project
PROPOSED DEVELOPMENT
HOSTMOOR AVENUE
MARCH

PROPOSED ALDI FOODSTORE
HOSTMOOR AVENUE, MARCH
TN01 – RESPONSE TO PRE-APPLICATION COMMENTS
17TH AUGUST 2020

DETAIL 2

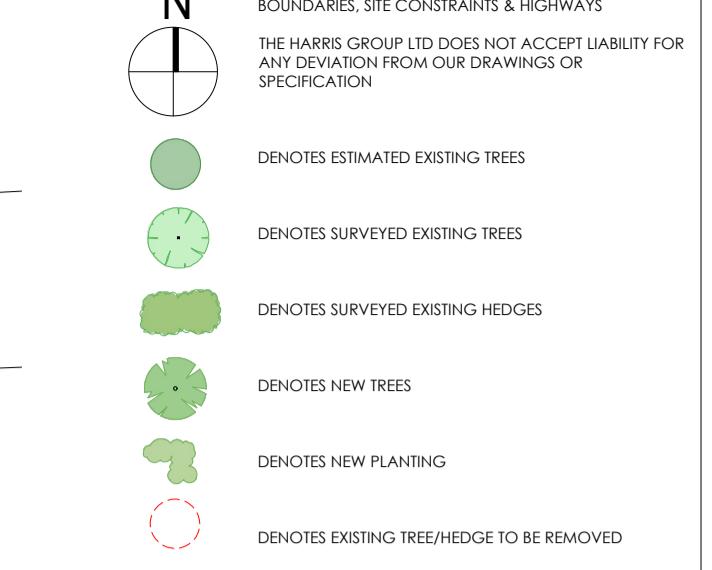
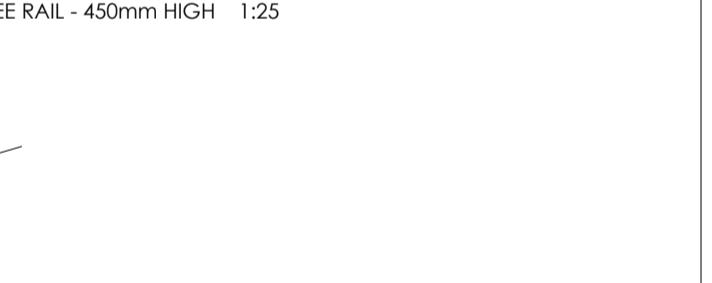
- "The Highway Authority does not support the proposed access arrangements, CCC Highways have requested that the access is taken from the lower category road, and redesigned accordingly. Therefore, access should be taken off Martin Avenue. Hostmoor Avenue junction with the A141 is currently over capacity and the creation of a new access in this location without a right turn lane would cause a safety and capacity concern. Site access and servicing details should be agreed with Highways Development Management."*

- 4.2 The proposed development requires access from Hostmoor Avenue to accommodate the proposed site layout and for commercial reasons.
- 4.3 Based on discussions with Highways Development Management, we understand that the access will be considered to be acceptable by CCC if it can be demonstrated that there are no capacity or safety issues which would indicate otherwise. The TA already demonstrates that capacity is not an issue, and a stage 1 road safety audit will be provided.
